# CITY OF ALBUQUERQUE

March 21, 2014

**Re: Buddhist Housing, 308 Wisconsin St NE, Traffic Circulation Layout**  
**Architect's Stamp dated 3-21-14 (K19D147)**

TRAFFIC CIRCULATION LAYOUT

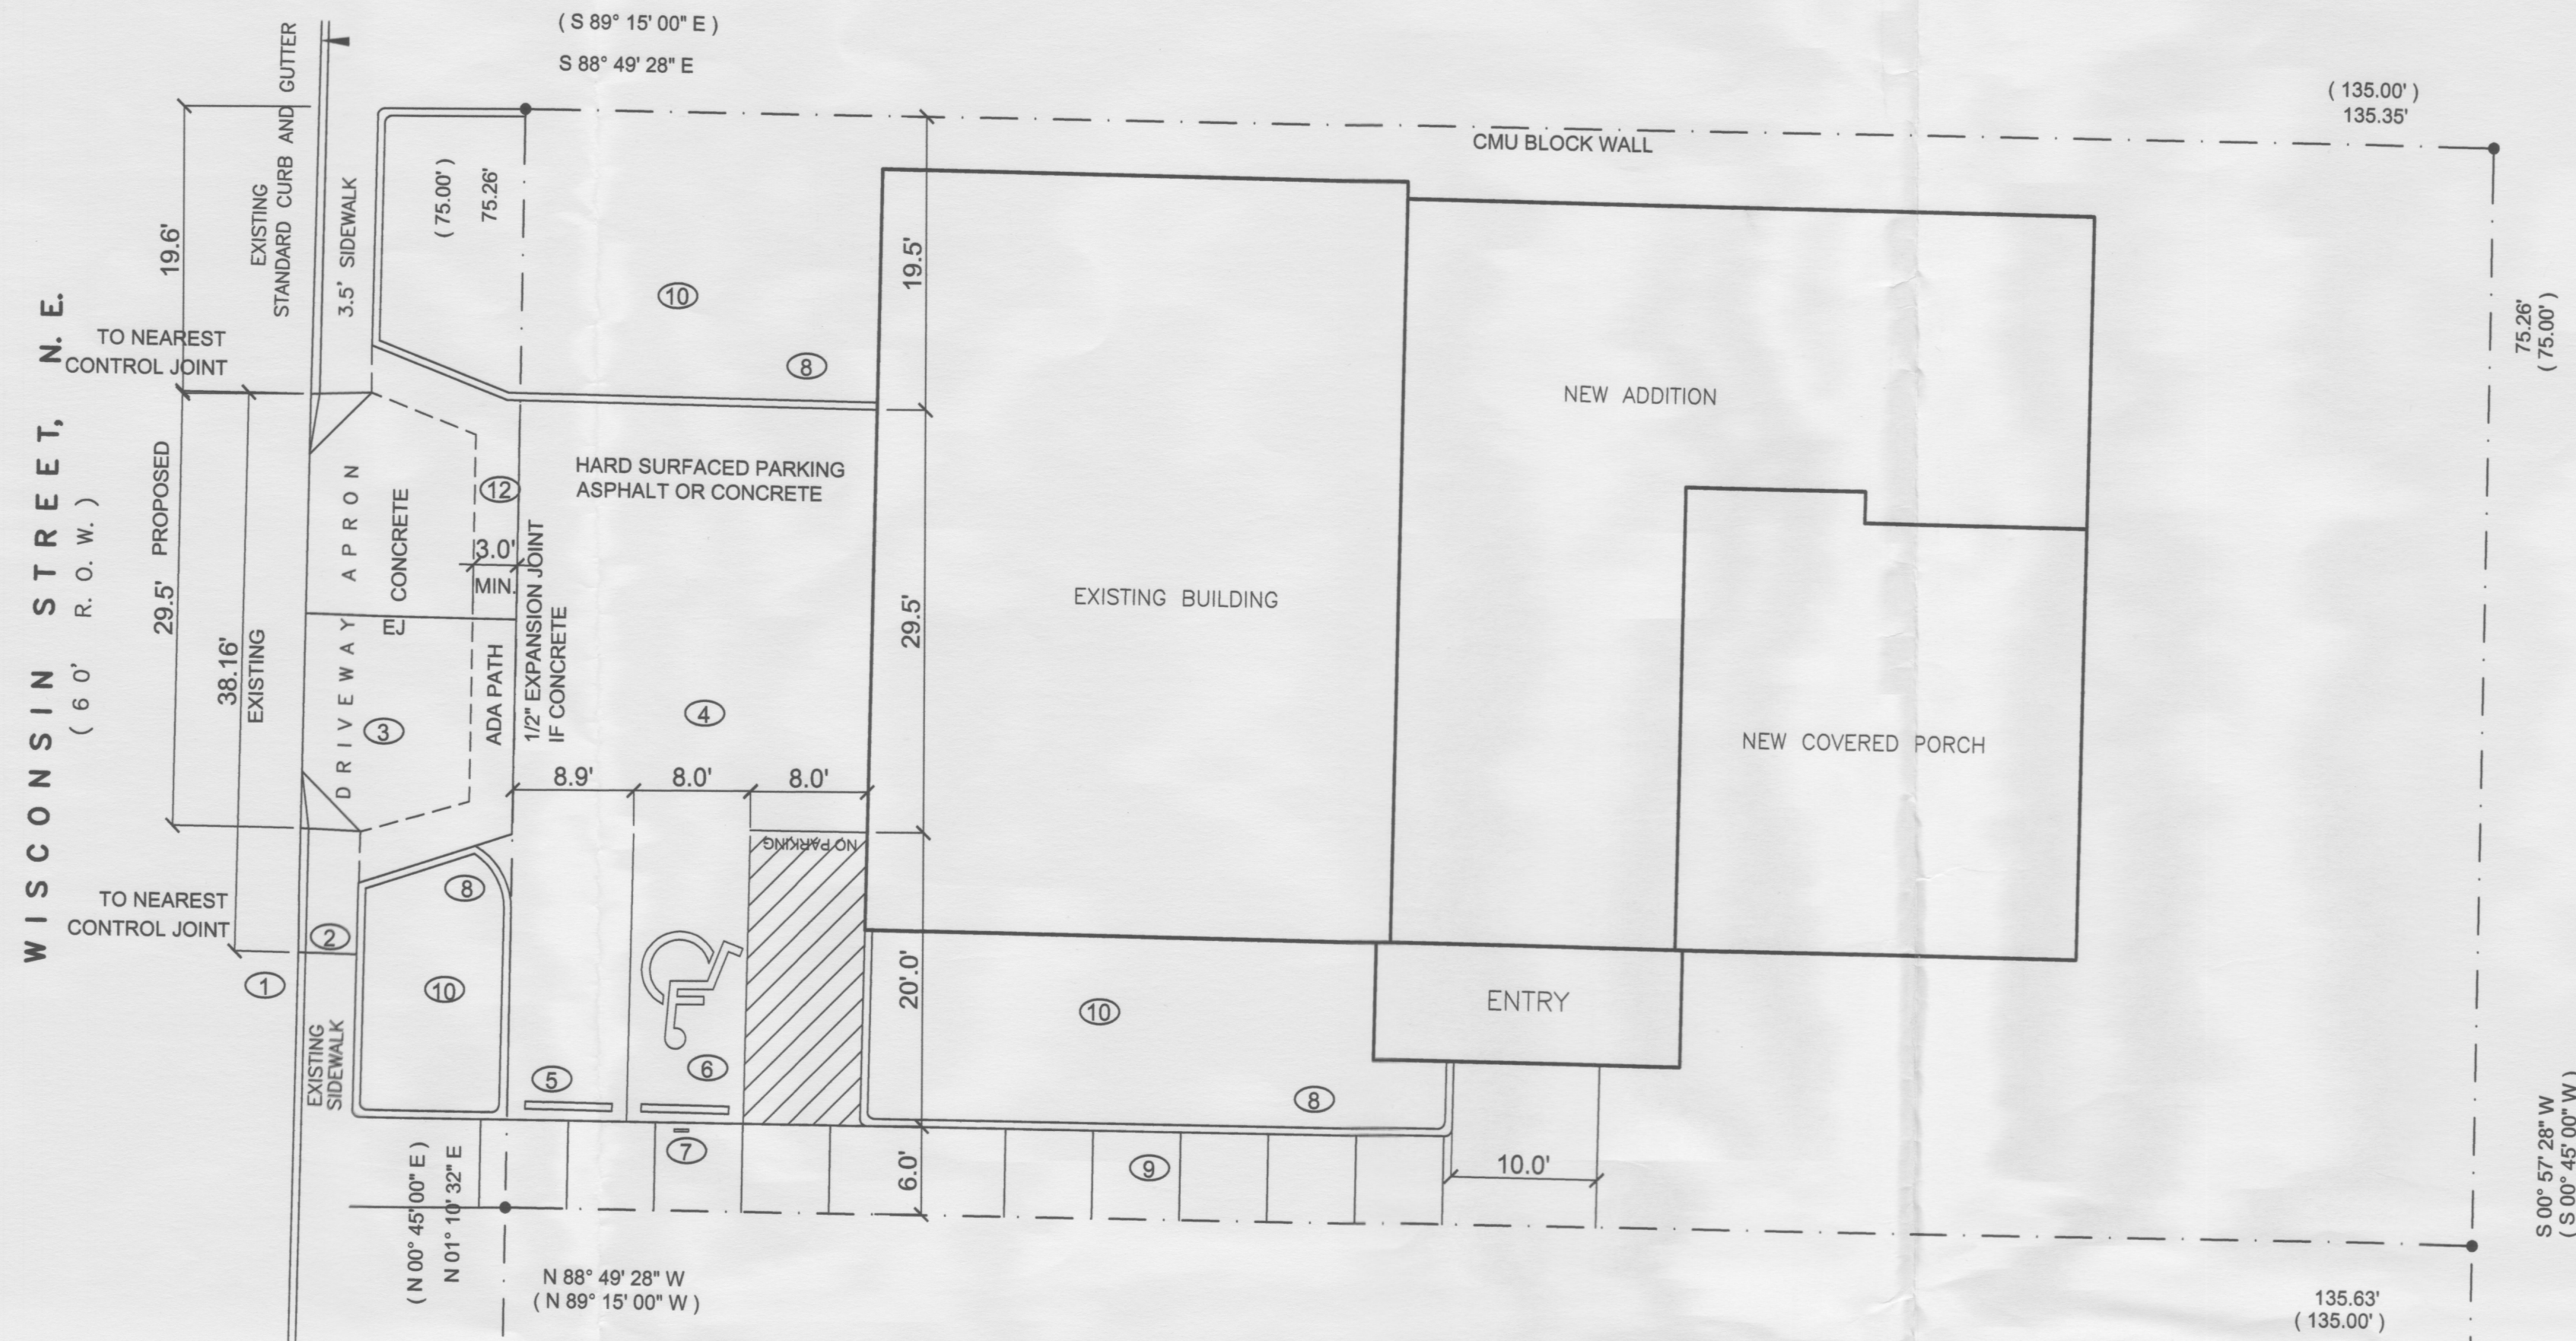
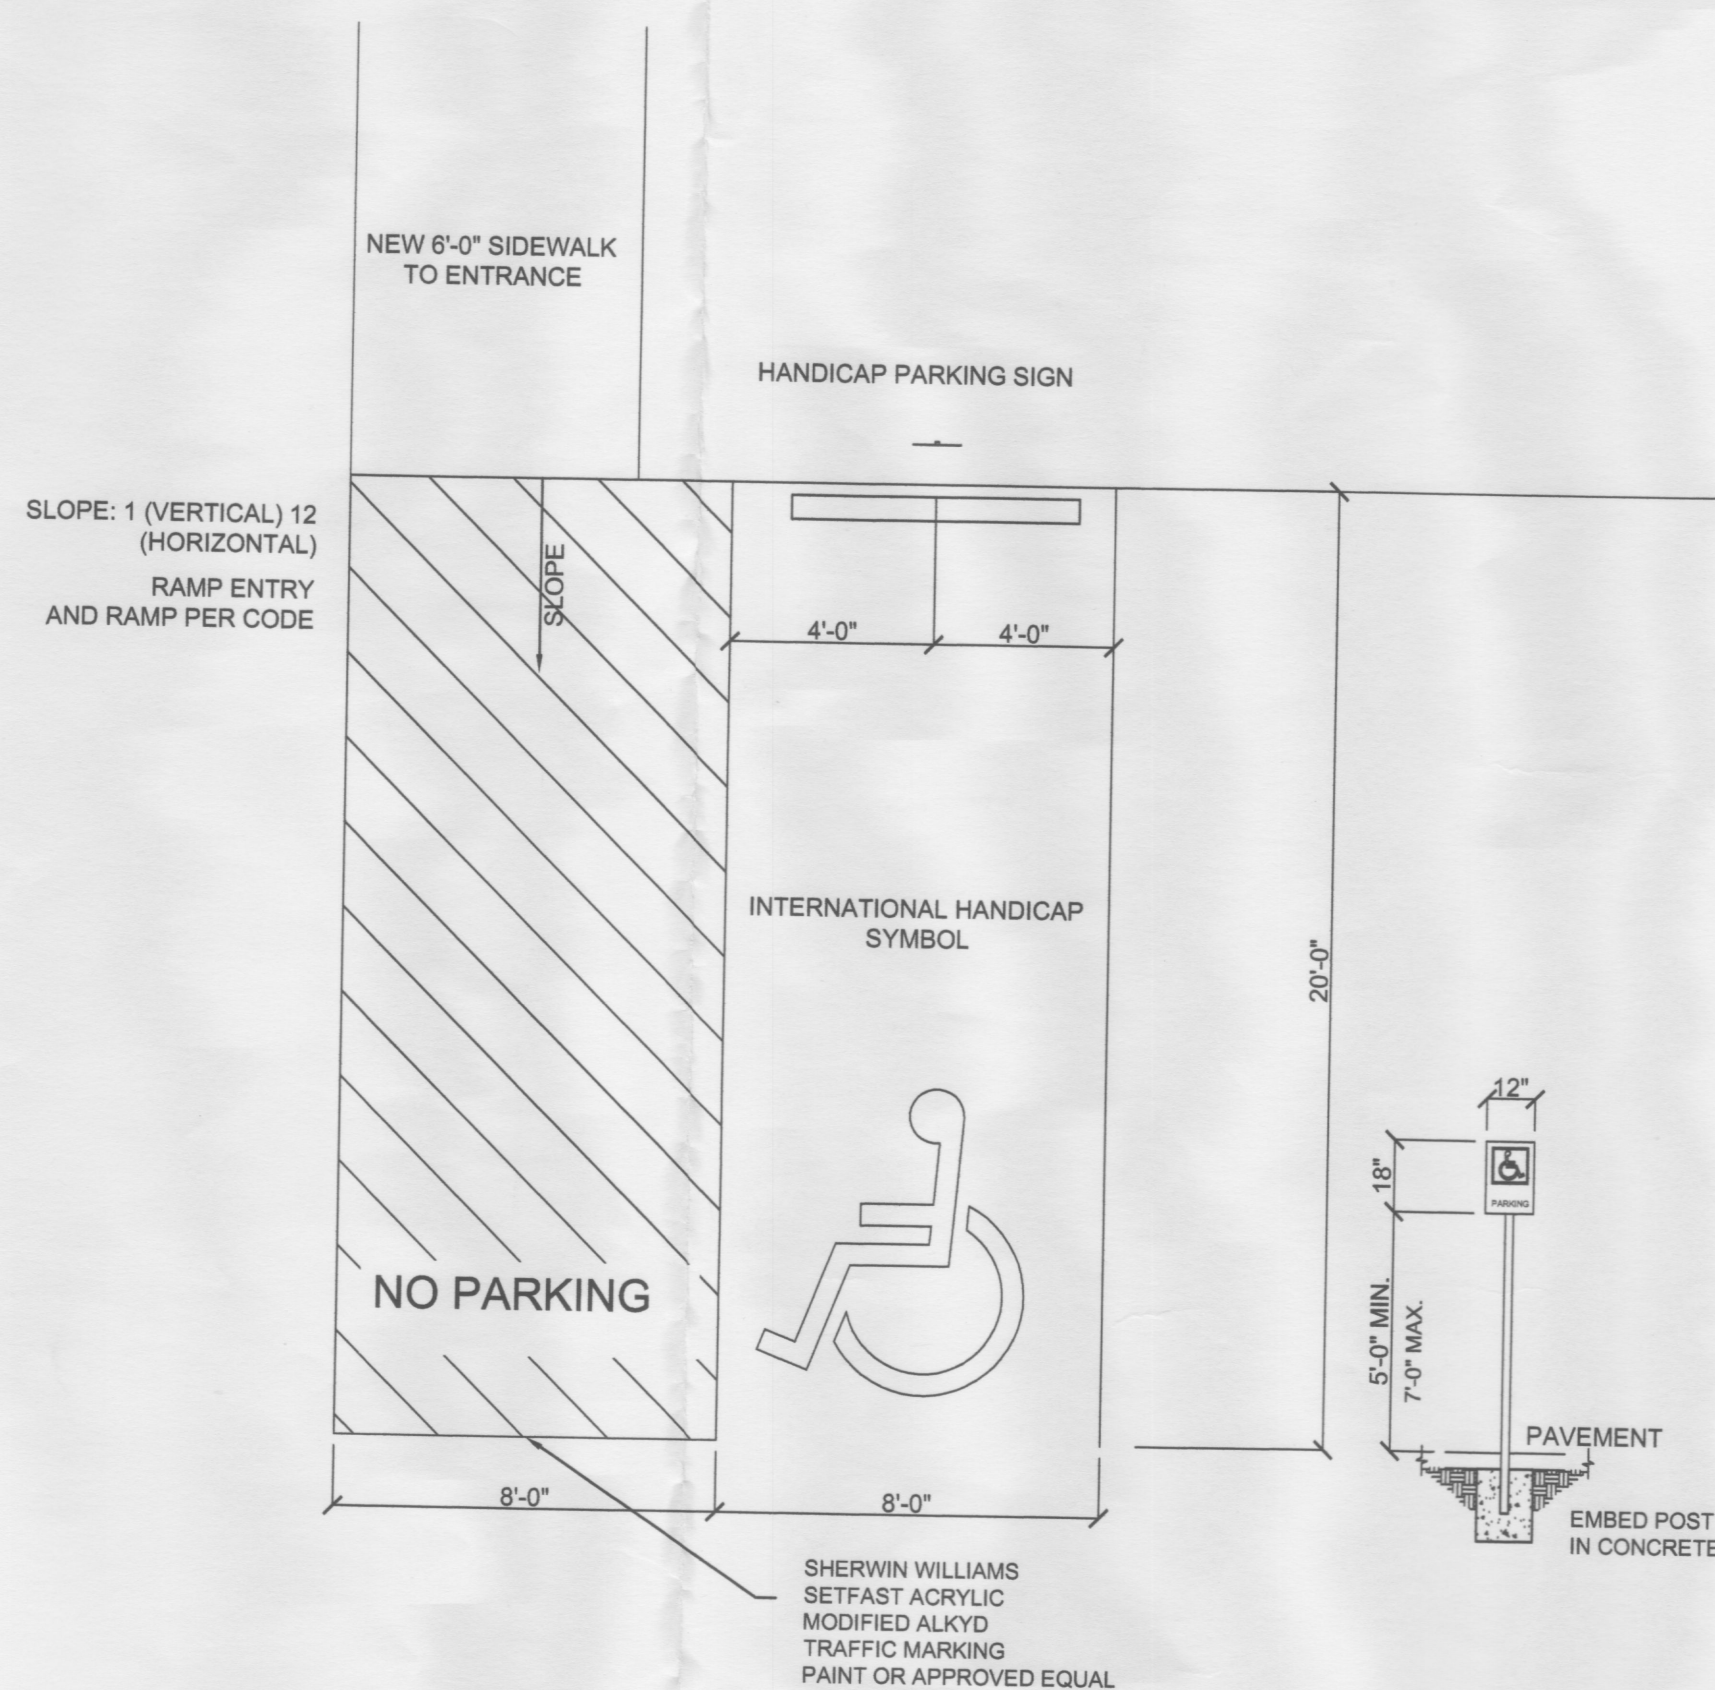
- Recheck the Legal description, what you provided does not match City's GIS.
- Remove text in TCL Legend that implies sidewalks intercept landscaping, notes 9 & 10.
- Remove note 2 and replace with different language to imply the existing drive pad is to be removed and replaced with COA standards for sidewalk, curb and gutter, COA STD DWG #2430 & #2415.
- The location of the new #2425 drive pad is provided w/ note 3.
- Add a note to clarify ADA sidewalk diverted to back of drive pad, minimum 3 ft, no greater than 2% cross-slopes.
- Clarify with line type what is to be built and remove lines that creates confusion, see attachment.

*Remove Existing Curb Cut  
Replace w/ COA STD DWG #2430 Sidewalk  
and #2415 Stno. Curb & Gutter.*

*12. 3' min ADA sidewalk ( $\geq 2\%$  Cross-Slope)  
located back of new drivepad.*

- Linetype is confusing - delete lines
- Appear to Propose large 5 ft transition wings.
- must show clearly 3' min ADA sidewalk
- Proposed (No greater than 2% Cross-slope)

1. The development of this site must be in compliance with current DPM and ADA standards and regulations.
2. Proposed parking can not cross into COA ROW.

3. Proposed parking requires backing into the street. Commercial zones require vehicle circulation to be contained within the site, no backing out into the public street.

4. Please clarify parking required by zoning and parking provided. It appears that zoning requires 2 parking spaces (1 HC w/ access aisle) and the TCL is proposing a total of 3 spaces.

7. It is not apparent what type of pavement surface is being proposed. A hard driving surface will be required as part of this proposed project for parking area and drive aisles.
